Norwich to Tilbury National Grid Electricity Transmission DCO

ExQ1 Brentwood Borough Council

Image 7.1 Interaction between TB228 to TB231, highlighted in green and the proposed LIH development

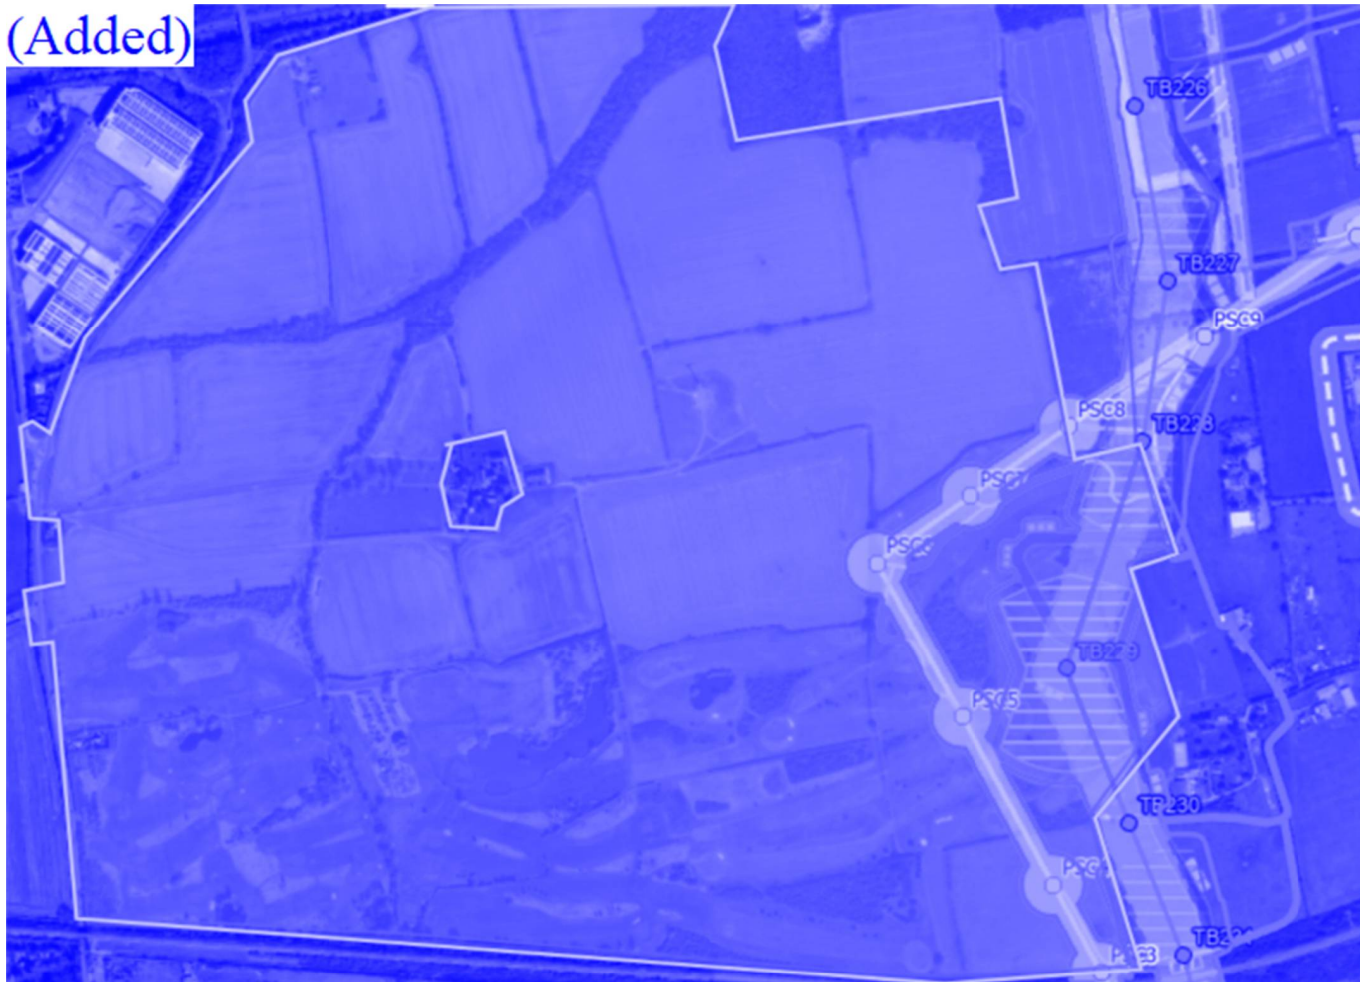
the affordable housing and associated infrastructure where no money is allocated to undertake this work. It is also noted that paragraph 22 of the LIH Relevant Representation (RR-0421) states "The scheme has been devised on the assumption that the existing 132kV overhead electricity lines will be removed from the centre of the site and diverted underground elsewhere".

c) BBC notes that ECC has reviewed the Applicant's comments in its response to RRs (REP2-023) and response to LIRs (REP2-030) and acknowledges the complexity of route selection, especially given the presence of heritage assets in the vicinity of Dunton Hall, but ECC has raised significant concerns about DHGV from the very start of this process when responding to the first Non-Statutory Consultation in 2022.

The amendments to the Norwich to Tilbury scheme which local authorities including BBC are seeking are considered to be relatively minor, and while the logic of following the safety zone for the high-pressure gas main can be understood, it does not in the opinion of ECC, supported by BBC, address the fundamental environmental concerns raised in respect of safeguarding the principles and objectives of the DHGV.

In maintaining its preference for this route, the Applicant refers to the proposed route being the least worst option in terms of its environmental effects. BBC believes these changes do not respect the design objectives for the garden village (or the wider development aspirations identified in current and emerging local plans). The Applicant in its defence of the route selection to the east of DHGV does not raise any technical objections to the
